## MEADOW LAKE INDUSTRIAL PARK REZONE

CS – Commercial Services and I-2 Limited Industrial to GA-O – General Aviation Overlay  
[Meadow Lake Airport]

### LETTER OF INTENT

SHEET TITLE:
COVER SHEET

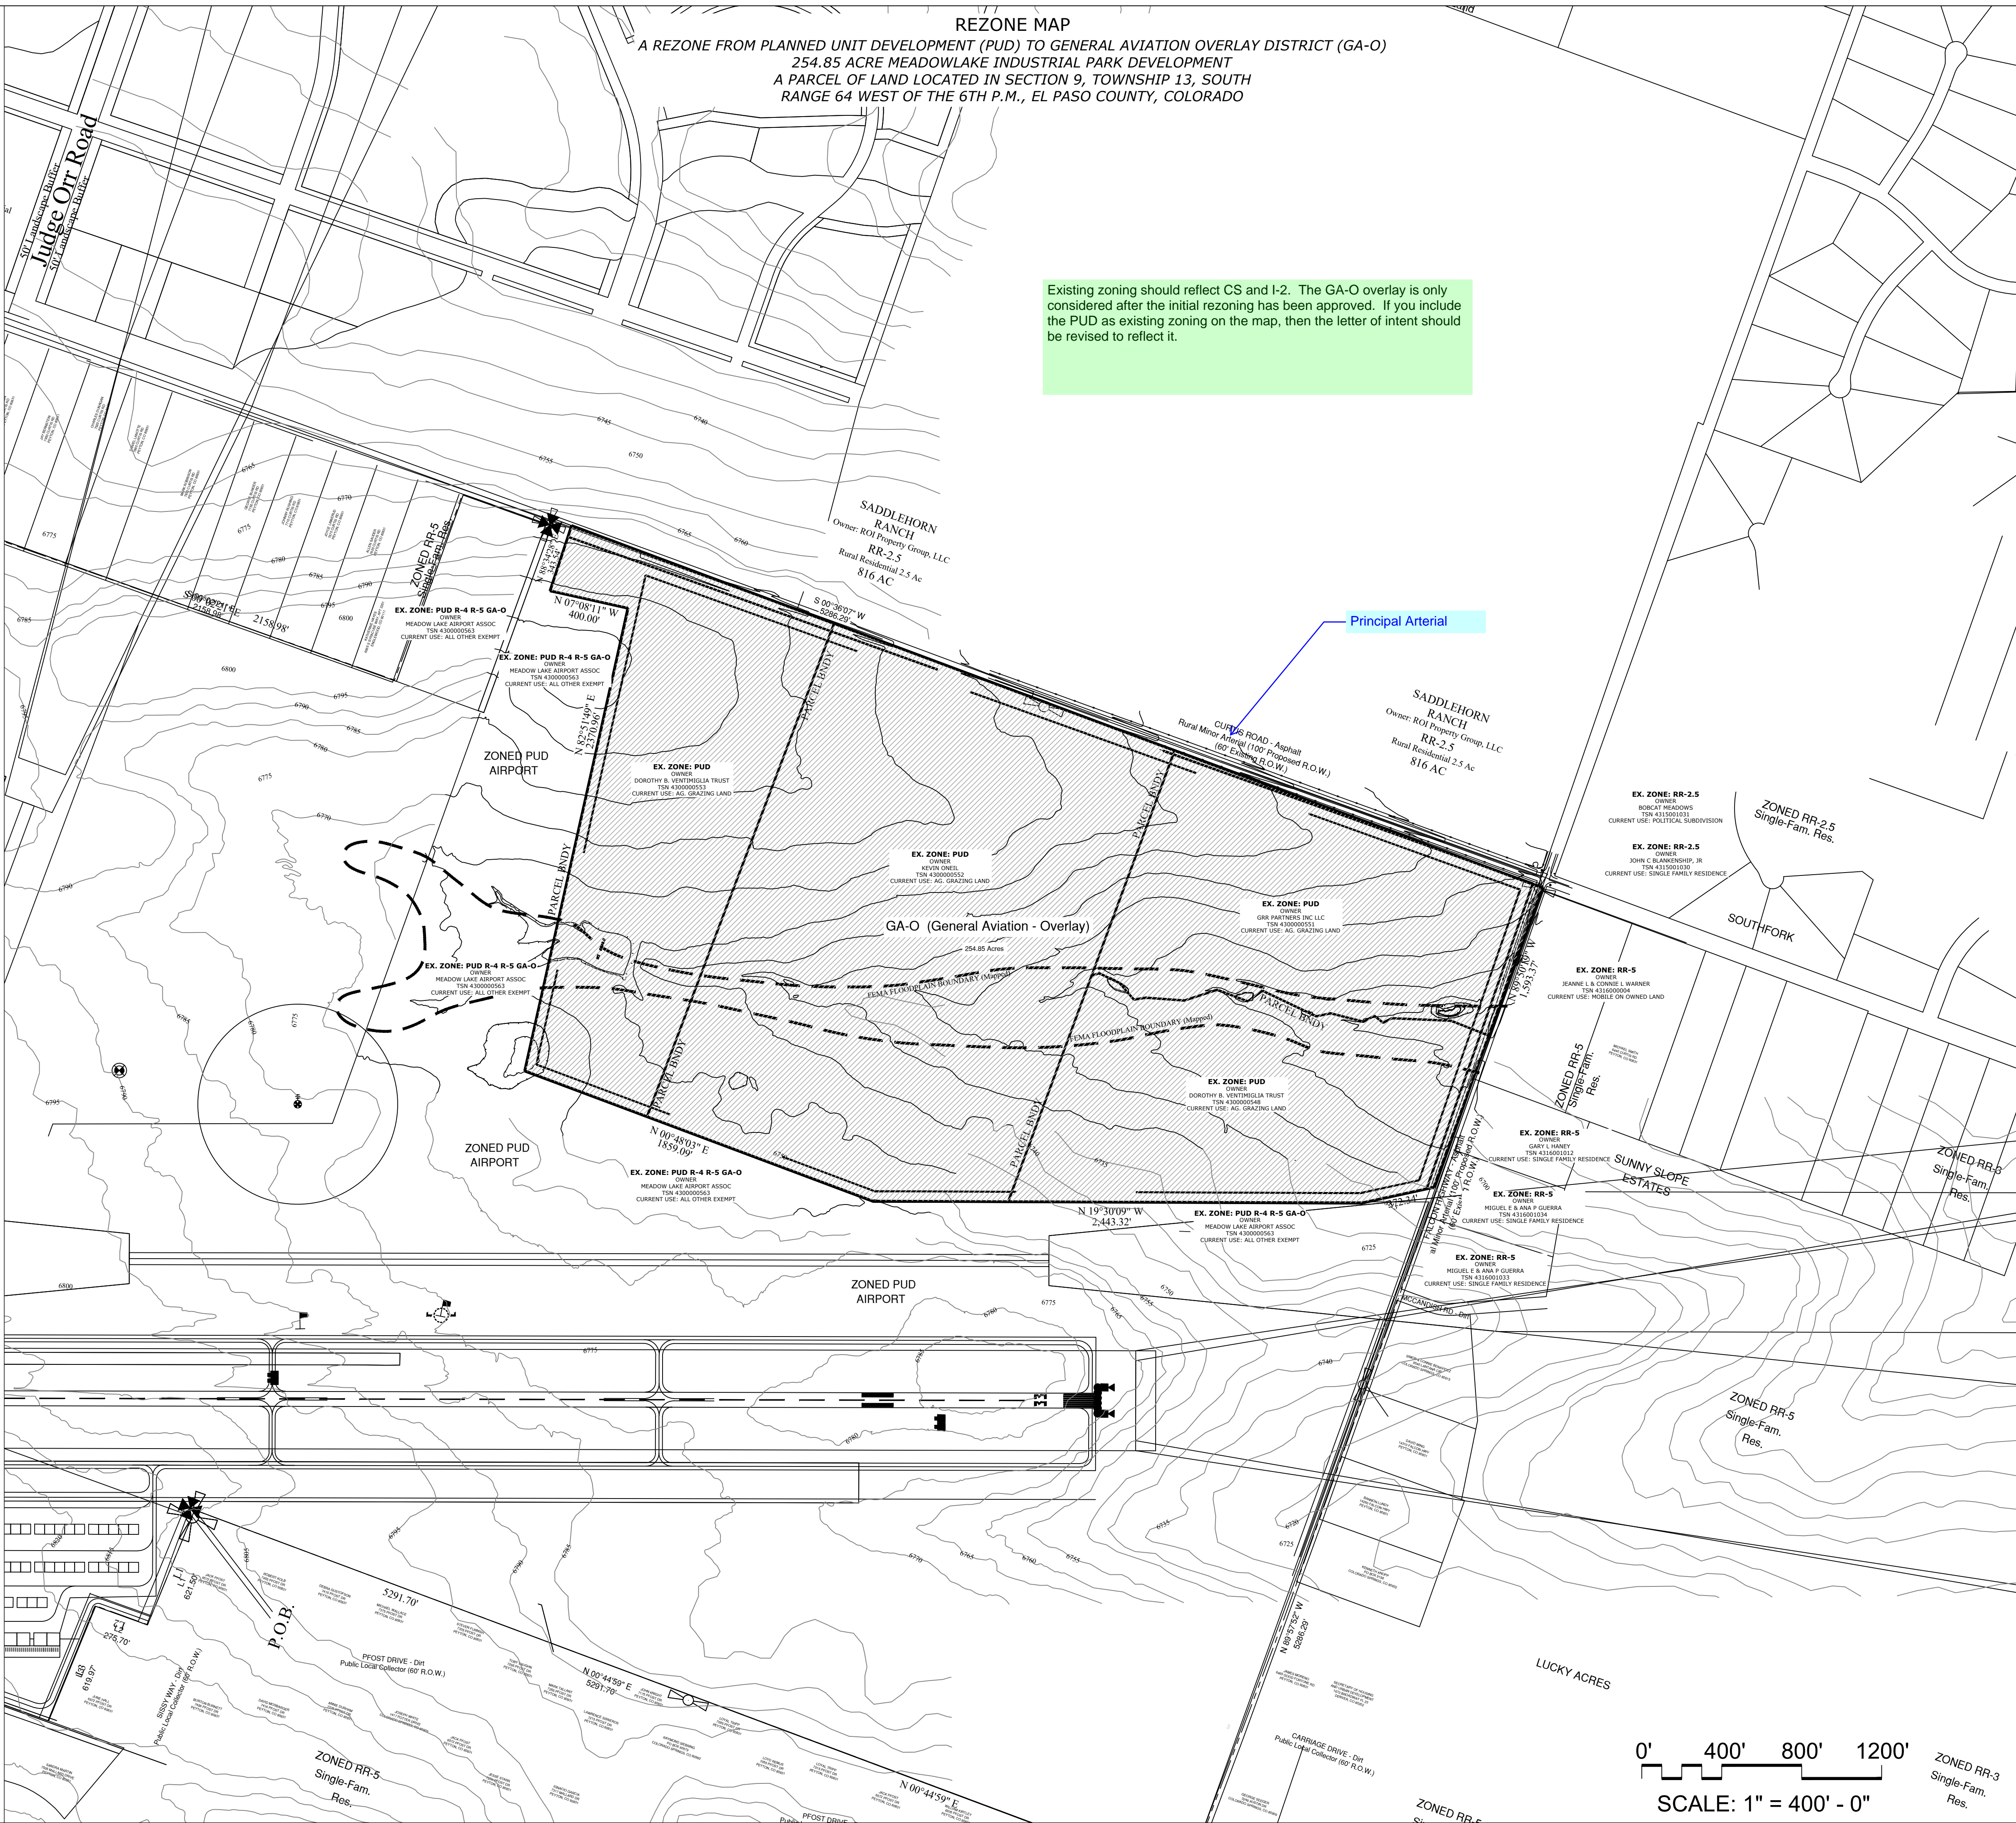
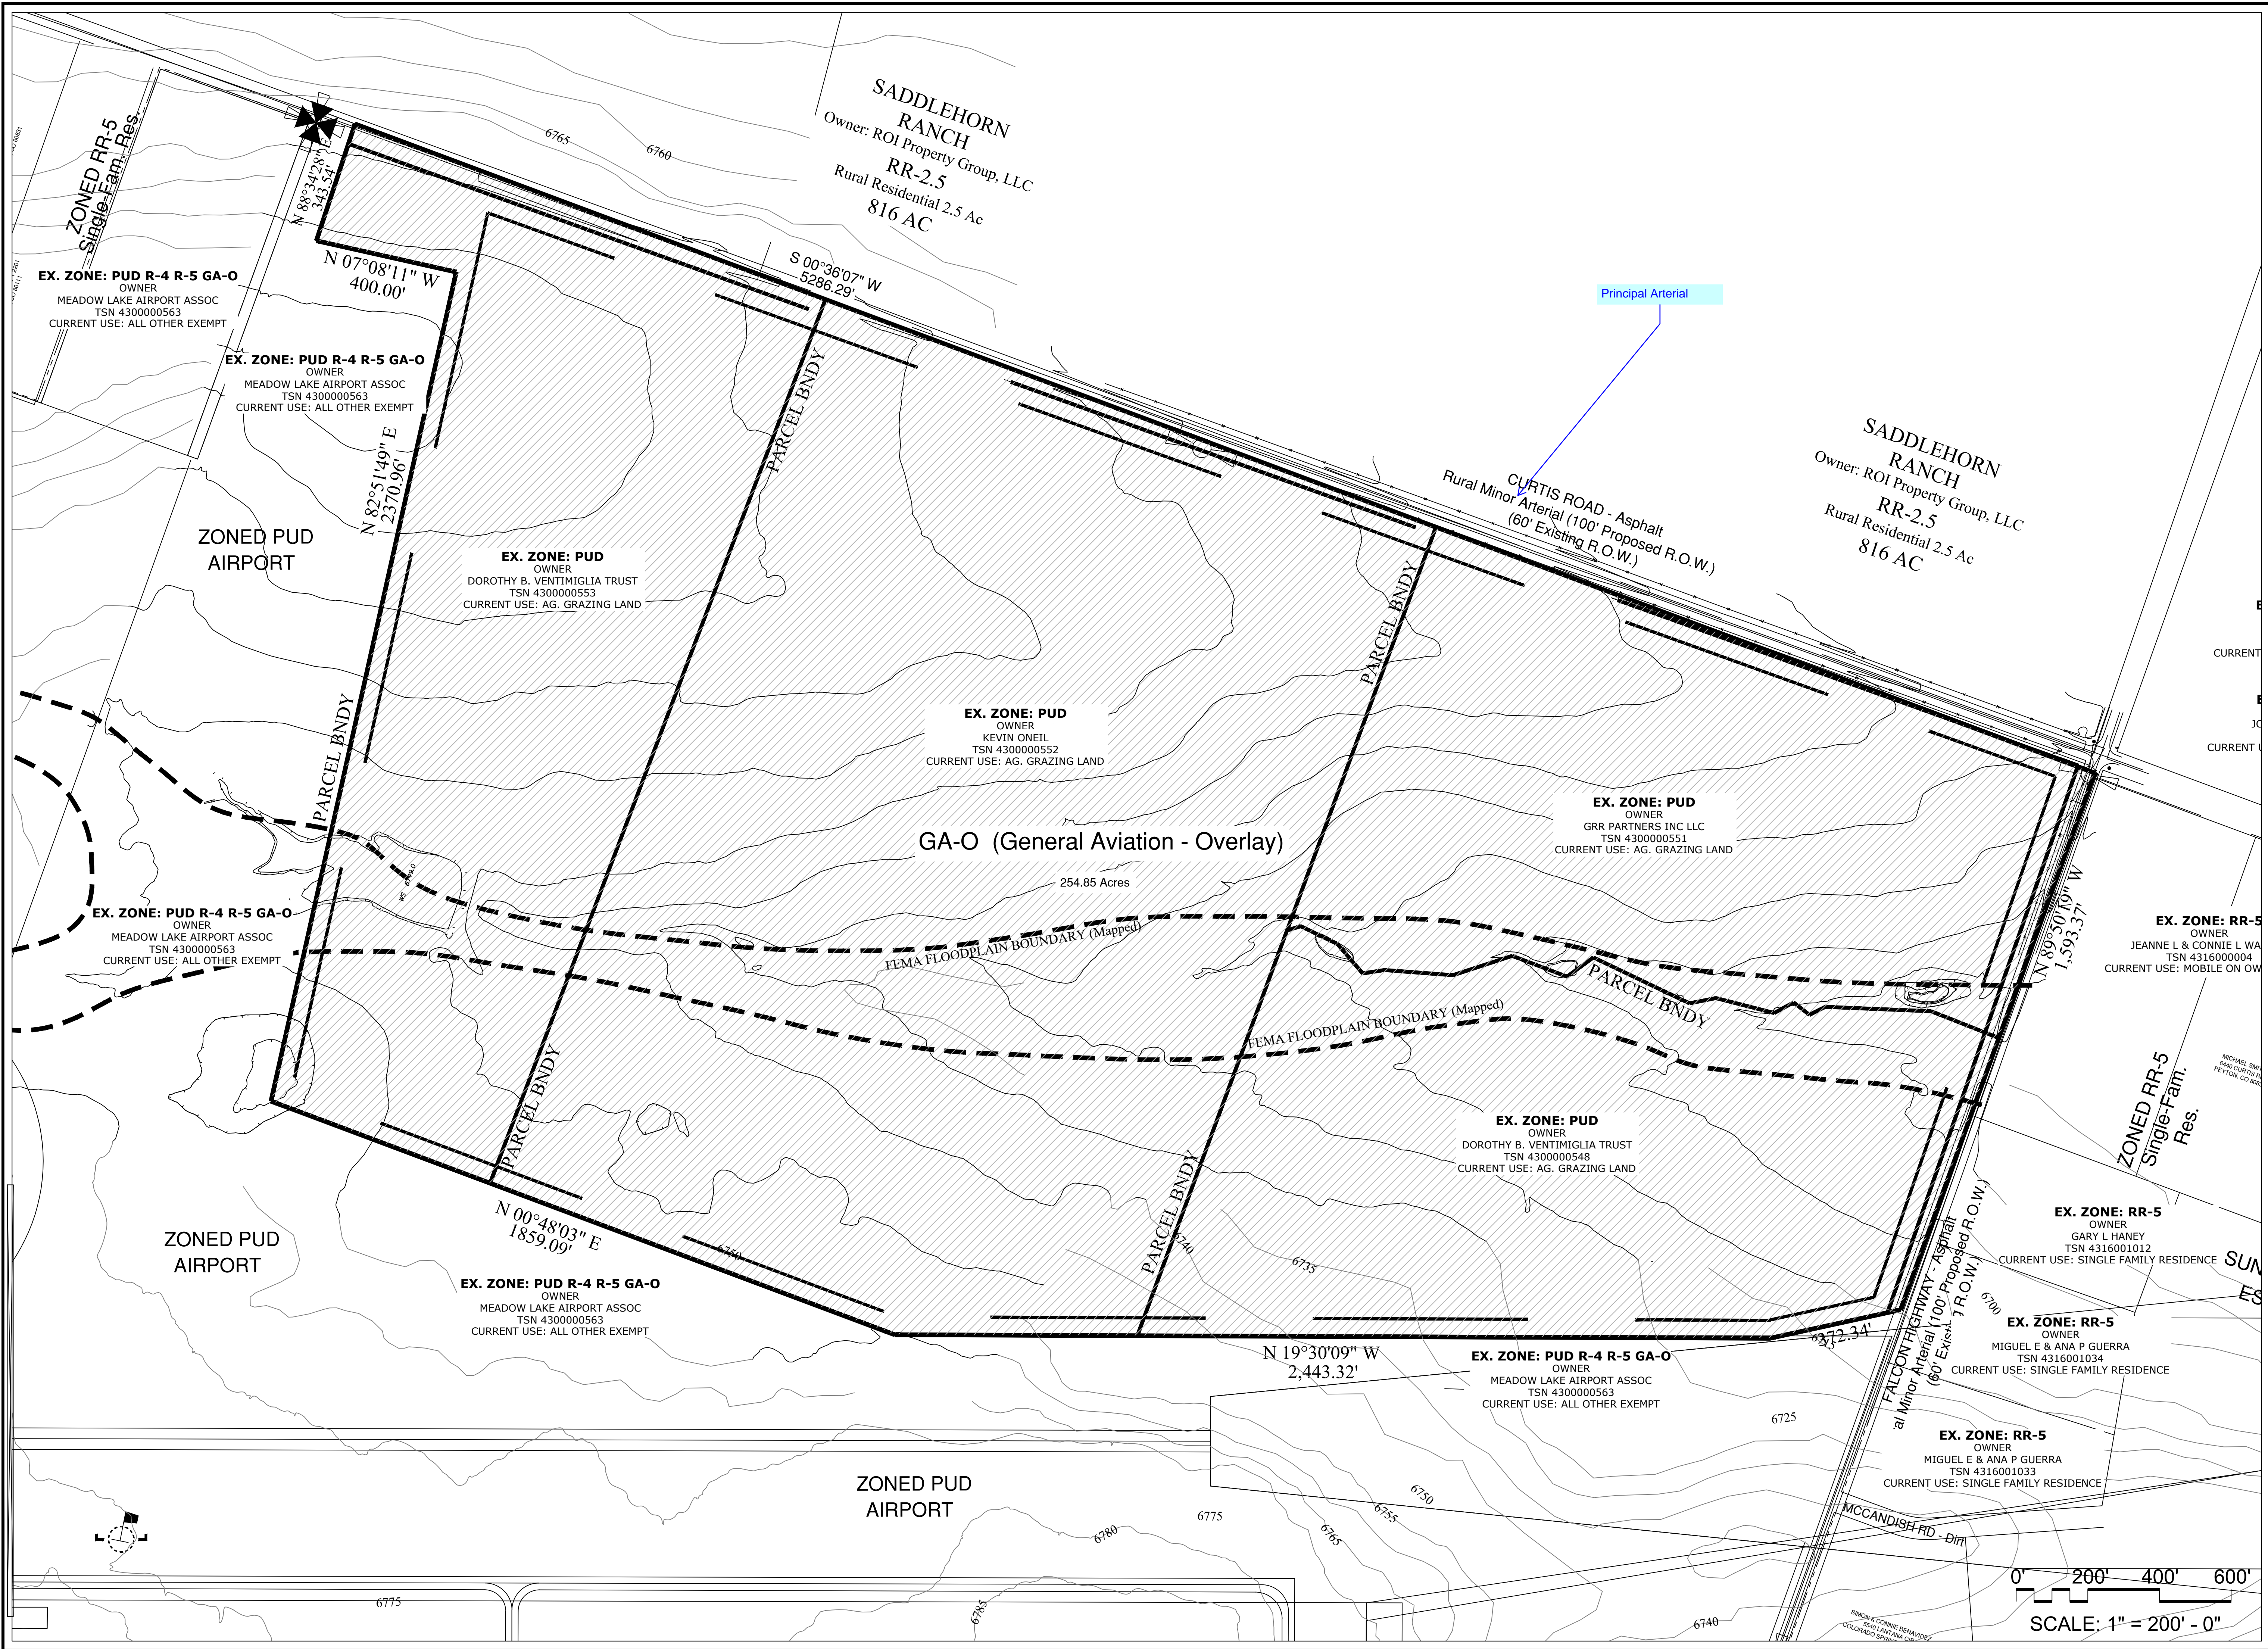
If you choose to keep the map as showing PUD as the existing zoning, then the letter needs to be revised as well.
